**WELWYN HATFIELD BOROUGH COUNCIL
ASSISTANT DIRECTOR (PLANNING)**

DELEGATED APPLICATION

Application No: 6/2024/1508/EMT
Location: 34 Sherrardspark Road Welwyn Garden City AL8 7JS
Proposal: T1 Hornbeam to reduce crown height and spread by 33% including dead, dying and crossing wood;
 T2 Silver Birch to reduce height by 33% leaving framework of branches and remove dead and dying wood;
 T3 Hornbeam to reduce height and spread by 33% including all crossed, dead and dying wood; &
 T4 & T5 Oaks to reduce spread (diameter) by 3 to 4 metres and height by 2 metres.
Officer: Ms M Hill

34 Sherrardspark Road, Site Plan 1:200

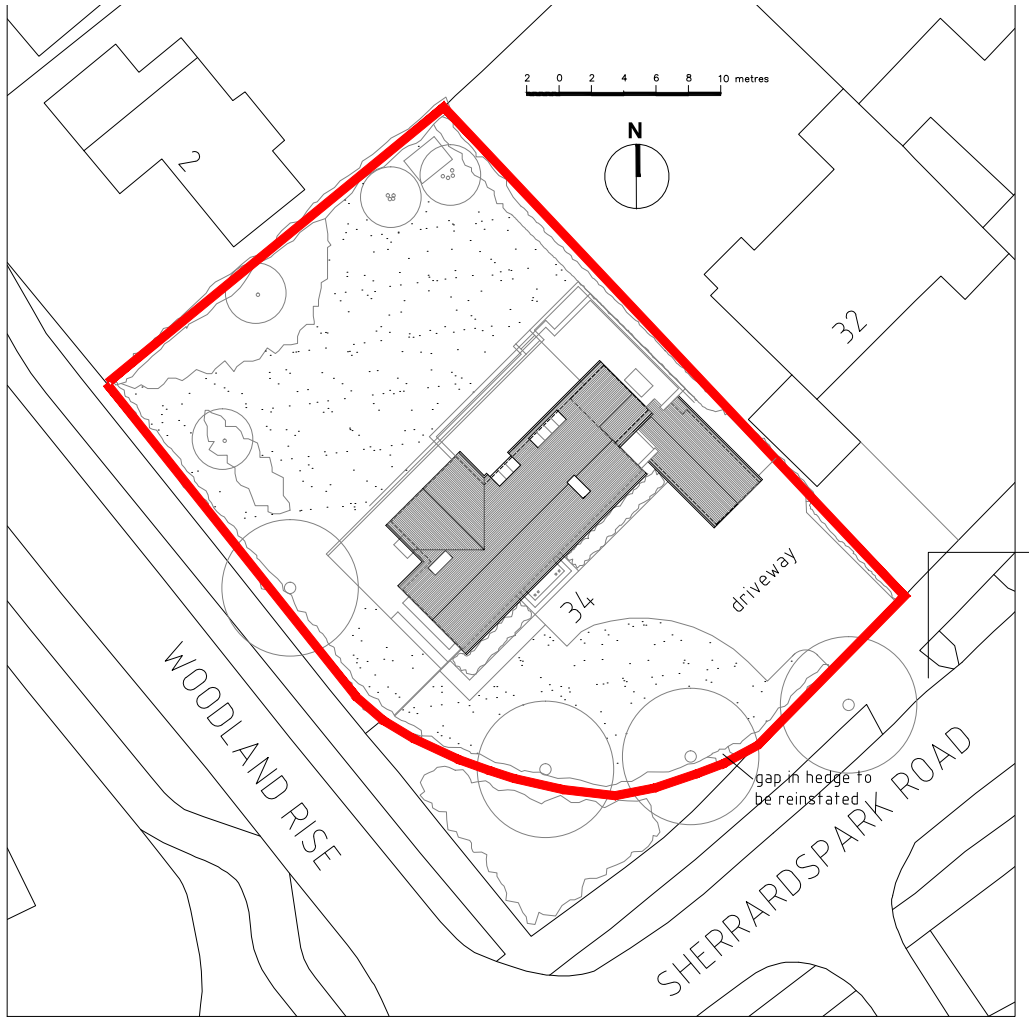
Consultations			
Neighbour representations	Support: 0	Object: 0	Other: 0
Summary of neighbour responses	None		
Consultees and responses	None		
Relevant Policies	Policy EM3 – Soft Landscaping		
Main Issues			
Appropriateness of the works in relation to the tree(s)	<p>T1 Hornbeam is a mature tree, standing by the roadside. It has a high amenity value. It appears to have reasonable health and vitality. The tree has been previously crown reduced with a high crown lift to 5m.</p> <p>The proposed tree works are to reduce crown height and spread by 33% including dead, dying and crossing wood. There are no dying sections of the crown and no significant crossing wood. The tree works proposal is slightly ambiguous and therefore a condition to limit/clarify the tree works is reasonable.</p> <p>T2 Silver birch appears to be the same tree identified in application/notice 6/2024/1535/EMT & 6/2024/1540/TC which proposes to fell the tree.</p>

<p>Therefore, these proposed tree works are reasonable.</p> <p>T3 Hornbeam is a mature tree with a medium stature, but tall. The tree has a good amenity value. The health appears fair with reasonable vitality. Structural condition unknown. There do not appear to be any particular problems or amounts of branches which could be associated with crossing, dead or dying branches.</p> <p>The proposed tree works are to reduce height and spread by 33%. This is an ambiguous proposal and should be limited through condition.</p> <p>T4 & T5 Oaks are very similar and therefore dealt with together. The trees appear to have reasonable health and vitality. Structural condition is unknown. The trees have been previously crown reduced and the regrowth is estimated to be between 0.75 and 1.5m long. Clarity was sought that the lateral crown reduction was off the lateral diameter and not radius. These works are not objectionable if appropriate conditions applied.</p>

3. The reduction points on T1 hornbeam, T3 hornbeam, T4 oak, and T5 oak shall be at the base of the branches which grew after the previous reduction and shall be to suitable fork/branch unions. No cuts shall be made below the previous reduction point.
